From: Sarah Burrow [REDACTED]
Sent: 04 June 2020 09:27
To: Planning.Responses <Planning.Responses@arun.gov.uk>
Cc: Simon Davis [REDACTED]
Subject: RE: Planning Consultation on: BN/39/20/PL

Engineers Comments Regarding Surface Water

APPLICATION NO: BN/39/20/PL

Site Address: Land adjacent to Tars Farm House Church Lane Barnham PO22
0DB

Figure 3 – Trial Hole Plan**Project**

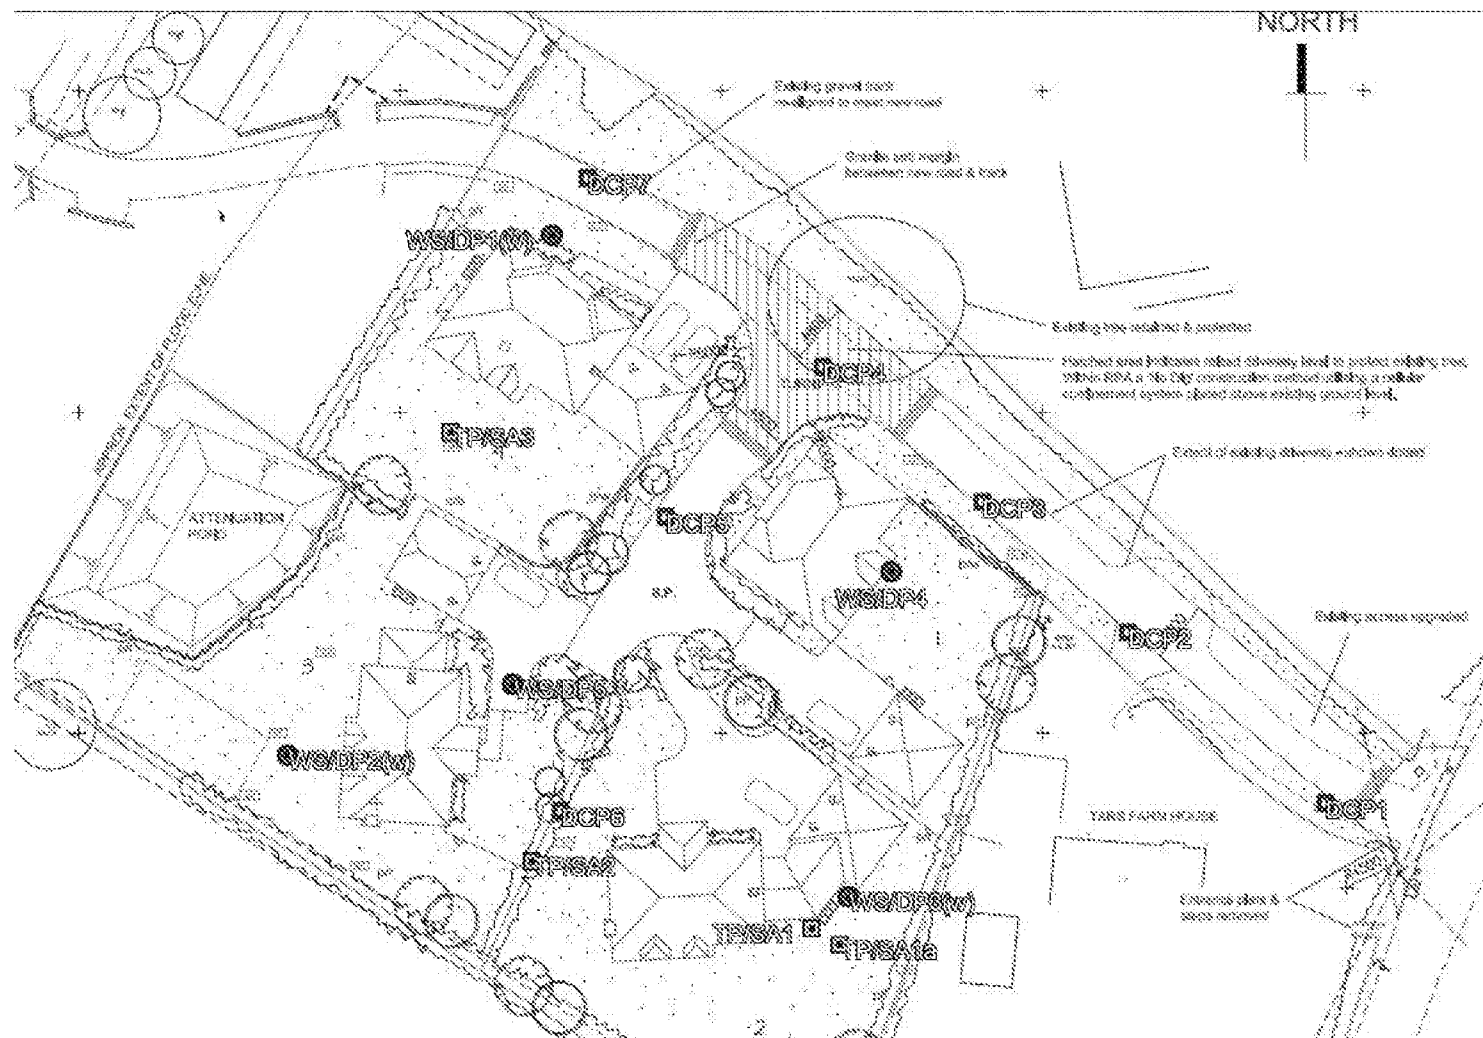
The detailed design still needs to be undertaken, as part of this stage we will expect to see the referenced SOILS Ltd report 17324/PIR detailing the full site investigation (referenced in the FRA). This must include mapping of the locations of the window sample bores. It is likely that we will expect the detention basin to be lined to prevent groundwater ingress and there is a chance that the basin may still need to account for floatation. The applicant will have to allow for the peak groundwater level which according to the FRA could be as high as 0.12mbgl, although without mapping this is hard to determine. We will not accept the argument that this figure is an anomaly given the location of the site and our knowledge of groundwater close to ground level in the area.

I am happy for this to be dealt with via condition if you are minded to approve the application. If so please apply standard condition PCENDG2 (copied below).
